Application Ref:	3/2026/0013			 <p>Ribble Valley Borough Council www.ribblevalley.gov.uk</p>
Date Inspected:	10/12/2025 (previous application)	Site Notice:	n/a	
Officer:	MC			
DELEGATED ITEM FILE REPORT:				REFUSAL

Development Description:	Proposed change of use from dwelling house (Class C3) to residential children's home (Class C2) for up to 2 children aged 4-18.
Site Address/Location:	2A Monks Drive, Longridge, PR3 3FR

BLOCK PLAN
EXISTING

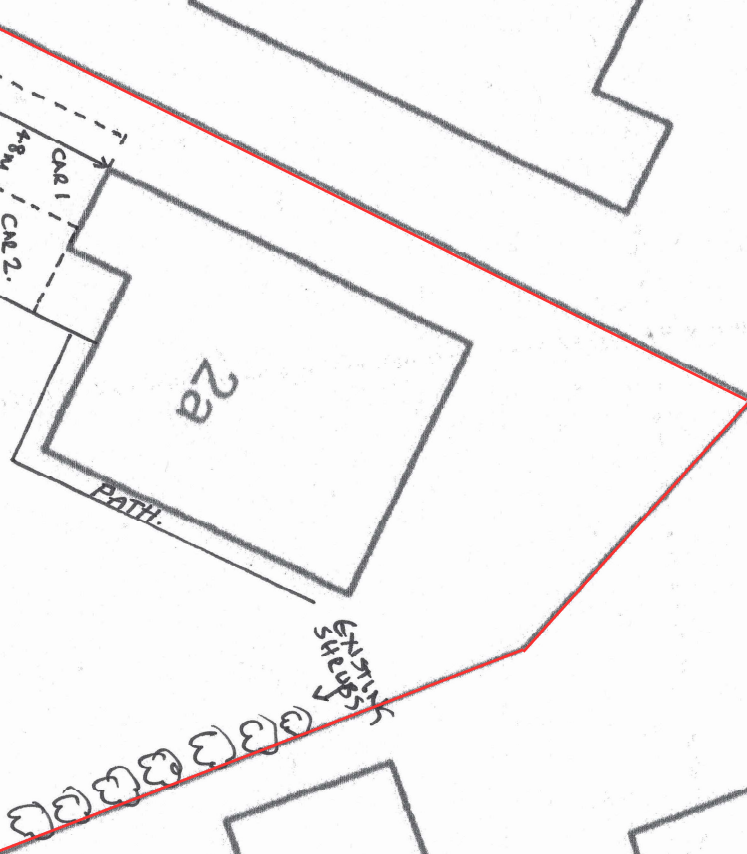
The LHA have provided updated comments on this application, stating that their comments remain regarding the length of the existing driveway space which should be 4.8m in length to count as a formal parking space. Having measured the existing plans as part of this re-submission application, the existing driveway does measure approximately 4.8m, the same as the proposed car parking spaces. However, the Council have uncertainties as to the actual length of the driveway, given the LHA’s previous concerns and the appearance of similar driveway lengths within the street only being able to accommodate a small car without overhang. There is ambiguity over this existing car parking space size and whether this can be formally considered a parking space.

Taking into consideration the above concerns and the ambiguity over the size of the existing car parking space, the Council still consider that proposed change of use is considered to result in an intensification of the use, without sufficient off-street parking provision. As such, the estimated vehicle numbers and frequency of staff changeover would likely lead to a reliance of on-street parking, to the detriment of highway safety, contrary to Policies DMG1 and DMG3 of the Ribble Valley Core Strategy.

BLOCK PLAN -  
PROPOSED OPTION 1

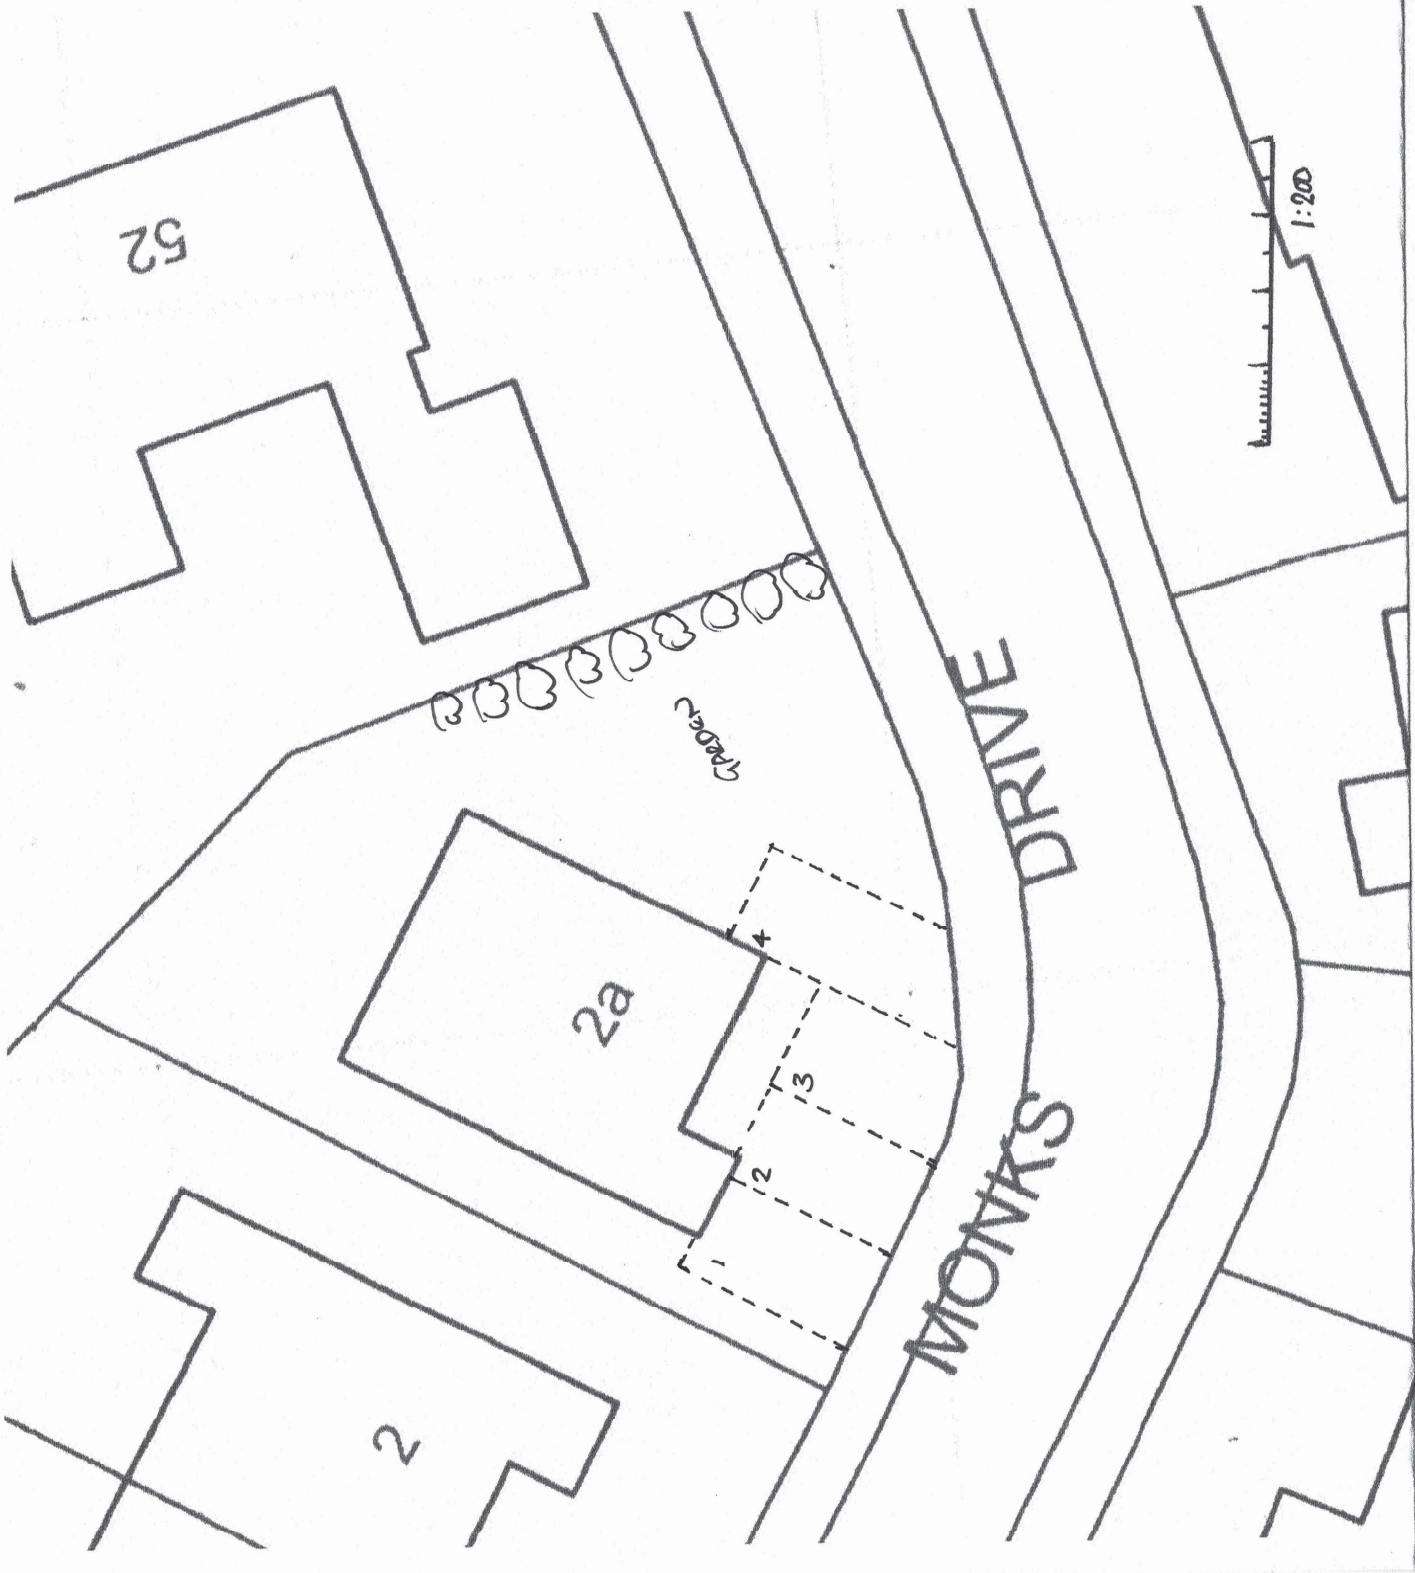
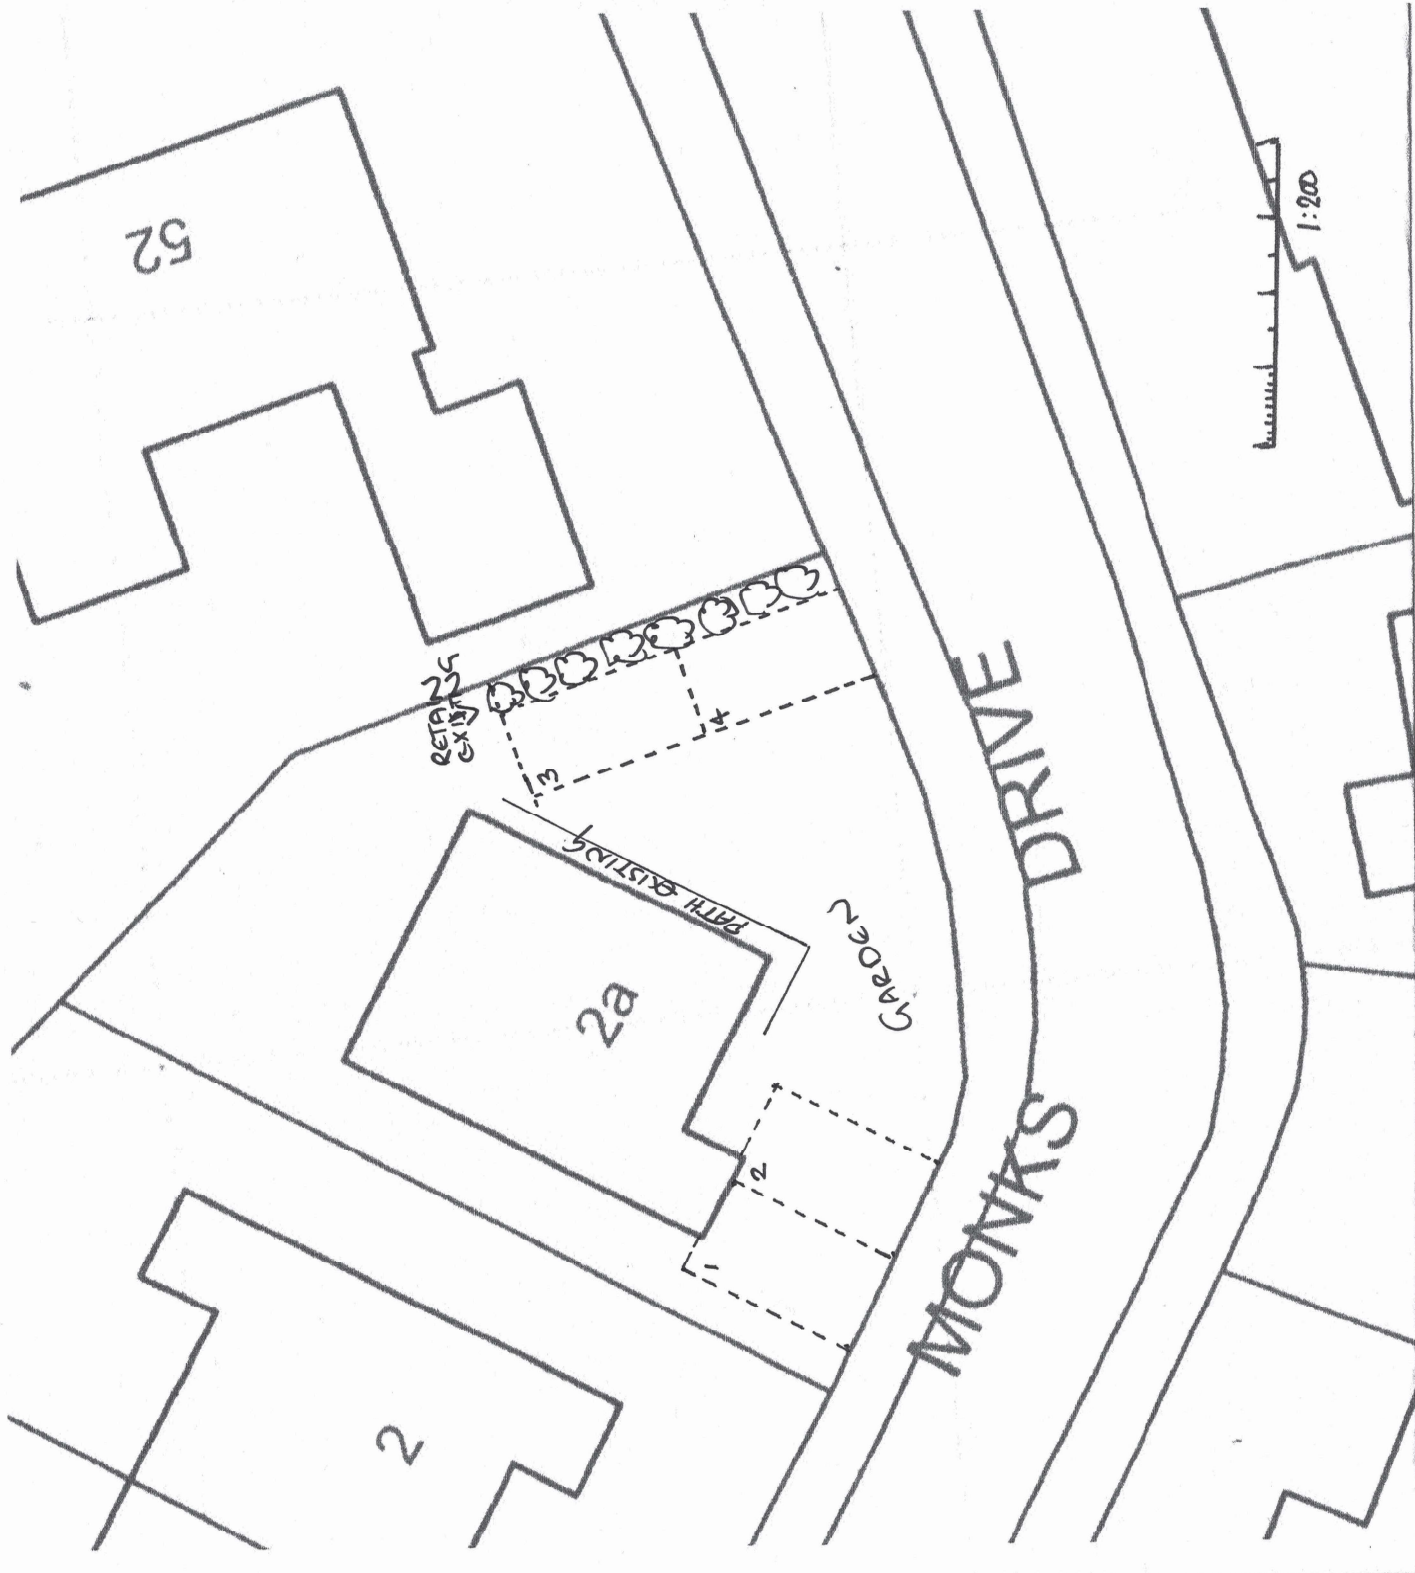
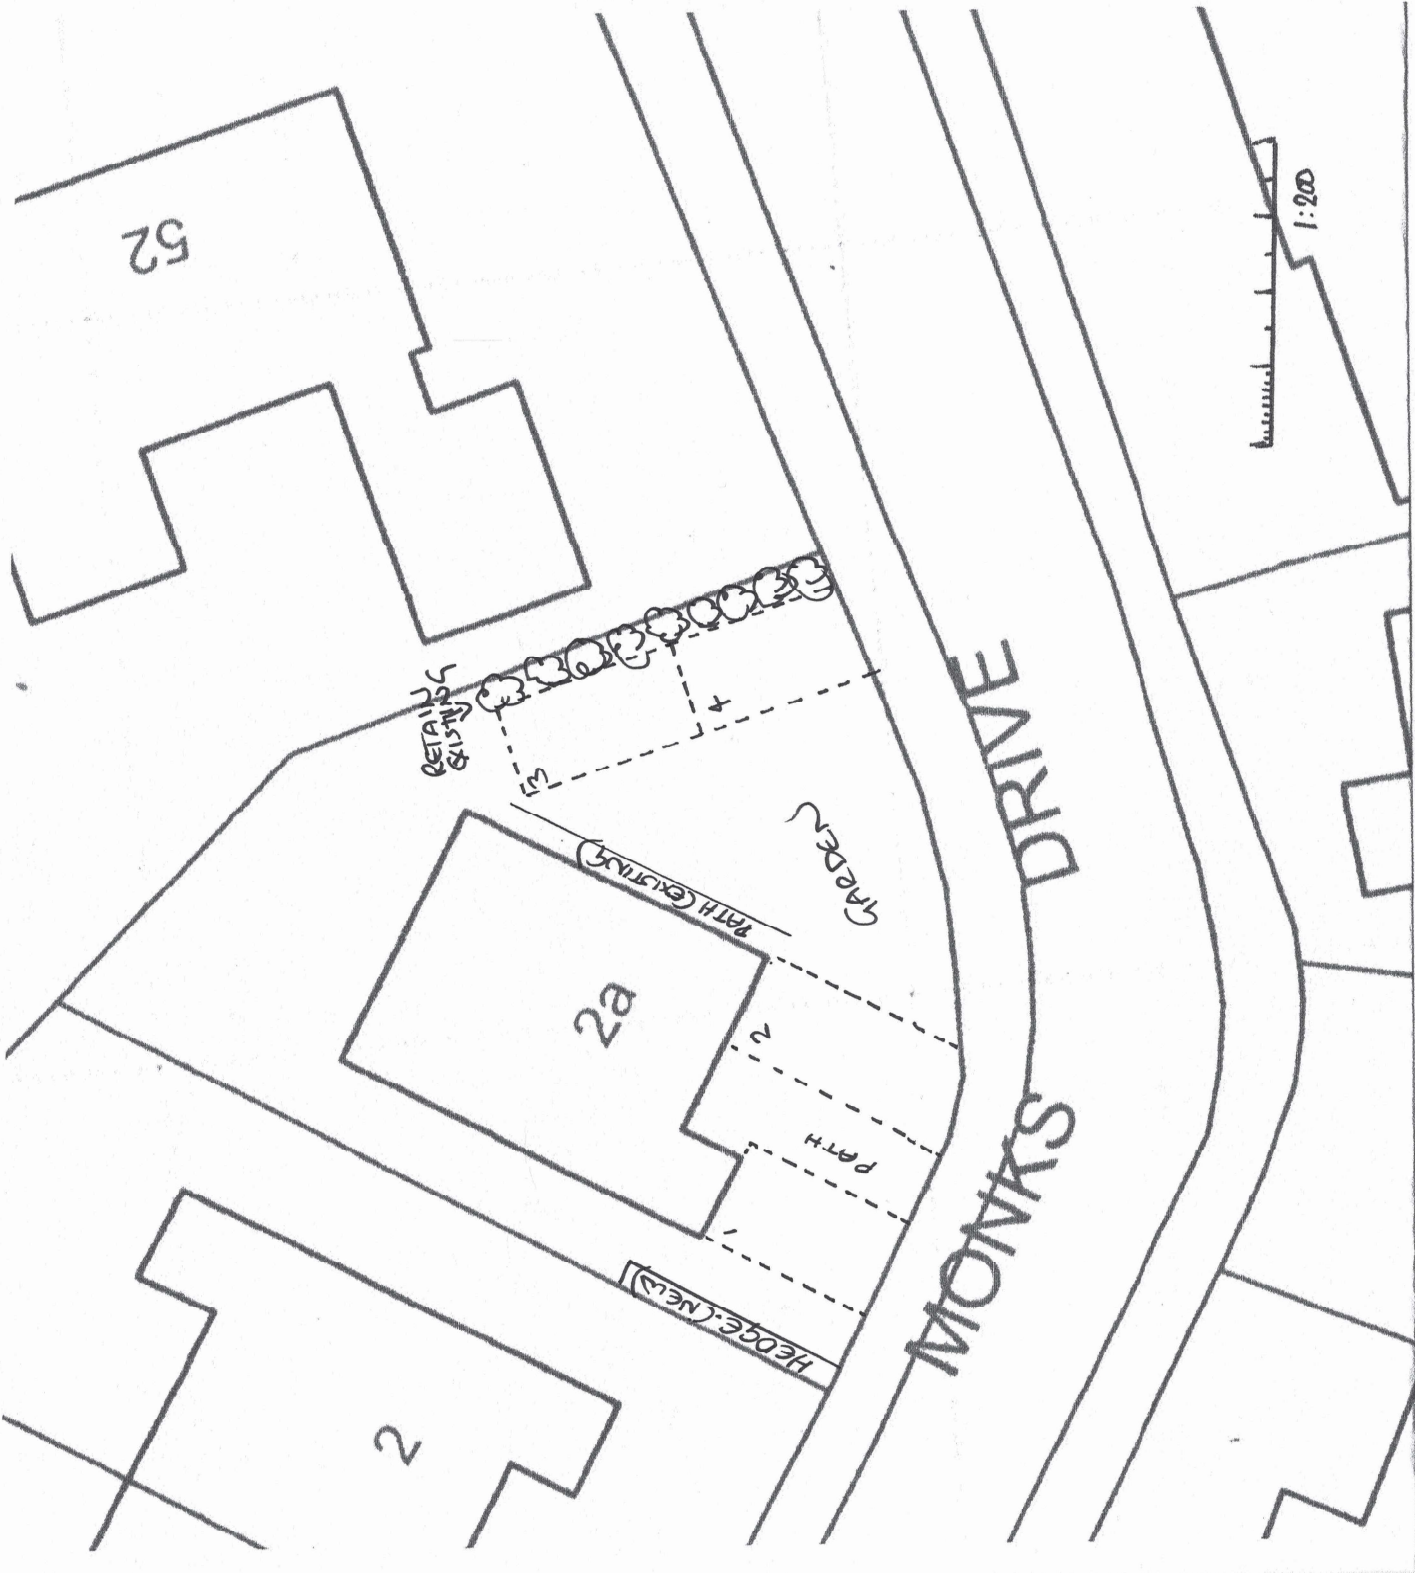
The proposal now includes the addition of three new parking spaces (two of which are tandem parking) taking the total number of spaces within the curtilage to four albeit the existing space has previously been assessed as substandard in terms of size.

The Council note the addition of 3 no. off road parking spaces. However, there are still concerns that as two of the parking spaces are tandem parking, the likelihood of both these being used is low given that the site is essentially a place of work for the staff who will want ease of access and manoeuvrability. In addition, although the highway authority state that the existing space is 4.8m in length, the Council retain concerns regarding the actual size of this parking space and its useability whereby larger cars/vehicles are likely to overhang the kerb. The worst-case scenario is that two staff members would park on site and the best-case scenario is four. However, even the best-case scenario would result in parking elsewhere in the street at change-over time and result in significant vehicle manoeuvring and associated noise and disturbance.

Whilst the applicant has put forwards a number of alternative parking options, which includes the parking spaces in a linear pattern, this would not overcome the concerns, and even more hardstanding would result in an additional visual impact to the character and appearance of the street scene. As such, it is not considered that the additional parking as proposed (or as suggested in another option) would overcome the reasons for refusal in the original application and the number of staff and frequency of staff changeover would still result in adverse impacts to the amenity of the occupiers of neighbouring properties due to the intensification of vehicles associated with the development and the likely reliance on on-street parking due to the size/siting of off-street parking provision.

The LHA have removed their objection to the scheme and recommend a condition be added to any grant of permission which ensures that the 3 no. parking spaces as shown on the approved plans are provided and made available for use prior to the first use of the site as a children’s home. Notwithstanding this, the Council have raised earlier concerns within this report as to the likelihood of members of staff using the tandem parking during changeover times, three times a day.
